33 Island Ave. - P.I.

2005-0134
Application I. D. Number

RE: Proposed Amendment to an Approved Site Plan
Inn on Peaks – 33 Island Avenue – Walkway and Ground Leveling
Application #2005-0134

TO: Ethan Boxer Macomber – Planner
FROM: Jim Seymour – Development Review Coordinator, Sebago Technics, Inc.
RE: The Inn on Peaks Island, Island Acquisition LLC
DATE: June 30, 2005

Drawing file: Building Permit / 050821plans.pdf

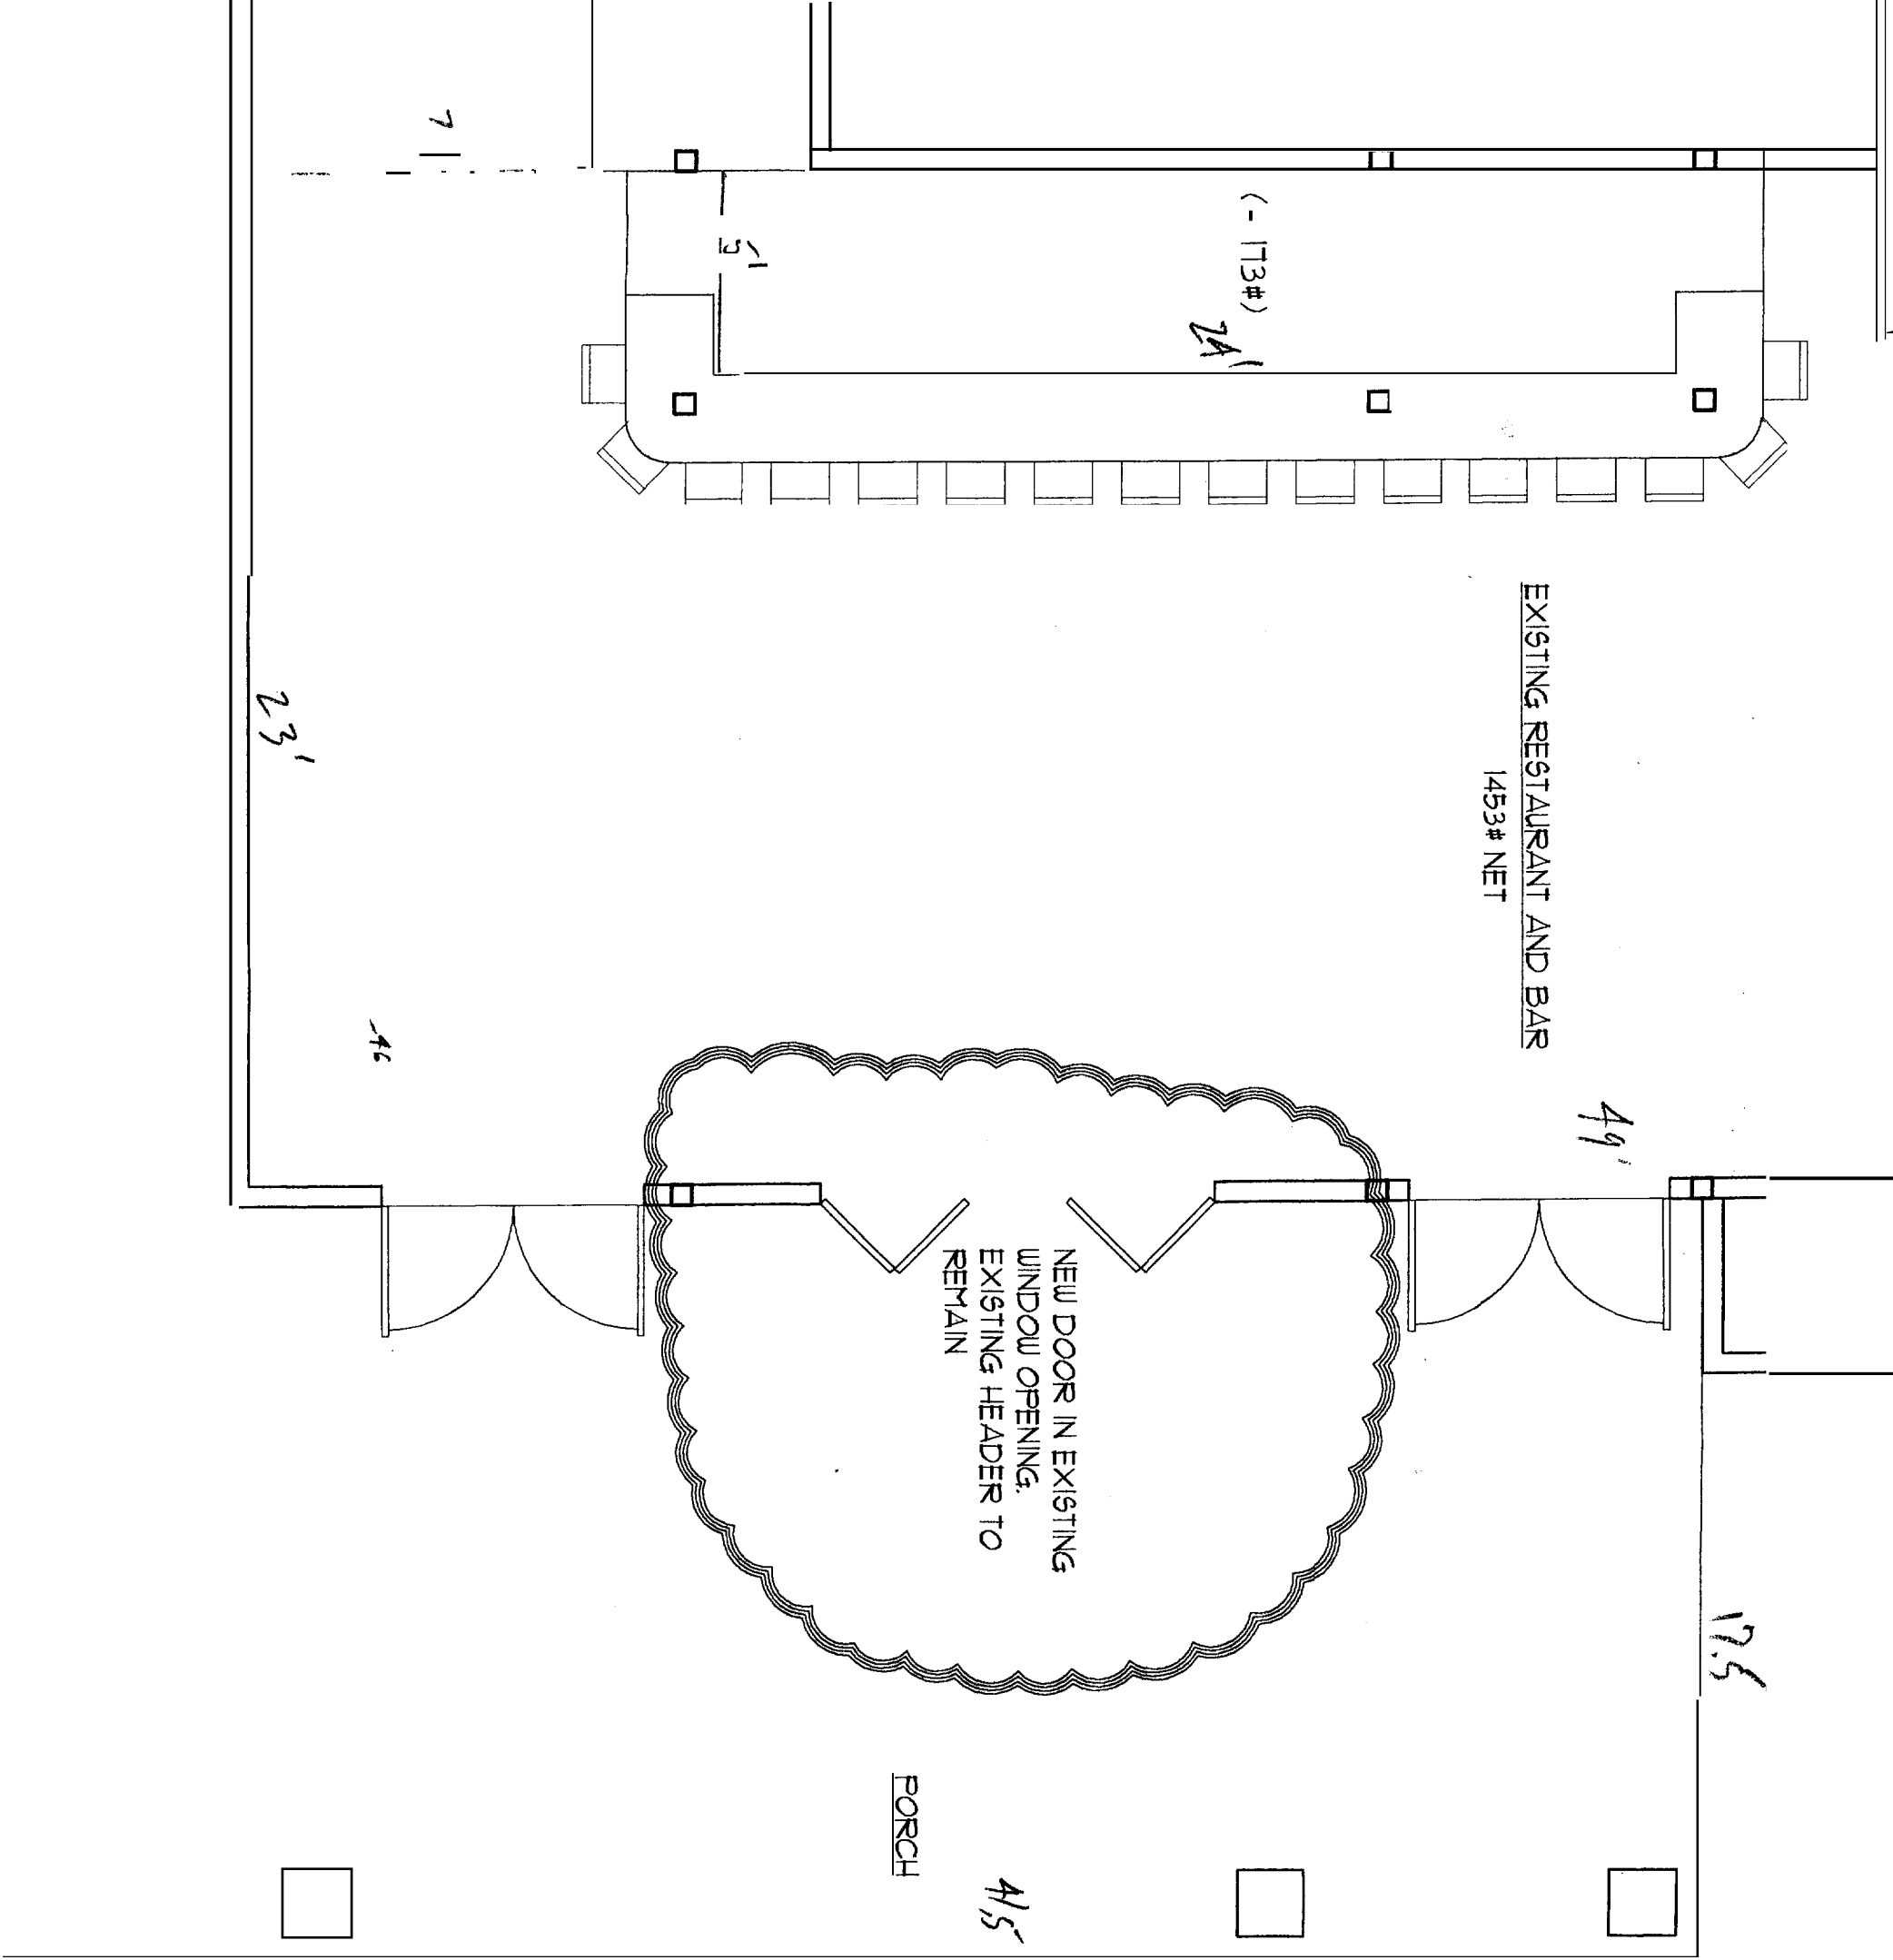
- A. The application submitted May 13, 2005 is for "Walkway and Ground Leveling", however the site plan submitted June 2, 2005 shows no changes to grades and no proposed walkway is identified.

- A. The surface conditions under the proposed canopy are brick, but the plans call for stone dust. Will the surface be regarded and reworked under the canopy? Appropriate BMPs will need to be shown installed on the plan. Also the applicant shall be responsible for sweeping and clearing the parking area and all access from tracked soils, and or dust from tracked materials.
- B. Drainage from the canopy will drain under and through the covered area as shown. Please provide means of directing drainage towards the existing catch basin in Island Ave. We recommend a French Drain type of

installation along the drip edge and tying it to the street drainage. Due to seasonal use freezing will not be a problem or concern.

- C. The gravel surface between proposed gravel pads on the northeast corner of the building will be problematic unless a drain is installed or unless the entire driveway is capped in concrete or bituminous. Runoff will saturate the gravel and the difference in materials will create ruts along the edges and will further pond water and deteriorate both concrete and gravel surfaces. If the area was paved or installed with concrete both the maintenance conditions and life expectancy will be enhanced.

- A. Will electrical services originally placed underground for the lighting, in the canopy area still be utilized, or will a new service be set in place for lighting or general use?

- A. Please be advised that the site previously had contaminated soils (some removed offsite, some disposed on-site). All excavated soils will be tested and disposed of either on or off-site in accordance with MeDEP requirements for Special Waste. Please add notes referencing this concern.
- B. We feel if the applicant submits new drawings that the site work would be easier to follow if the pre-existing conditions were removed so that only current conditions were shown on the drawing. If staff does not have other concerns then the plans could be conditionally approved, per the items above. Please contact our office with any questions.
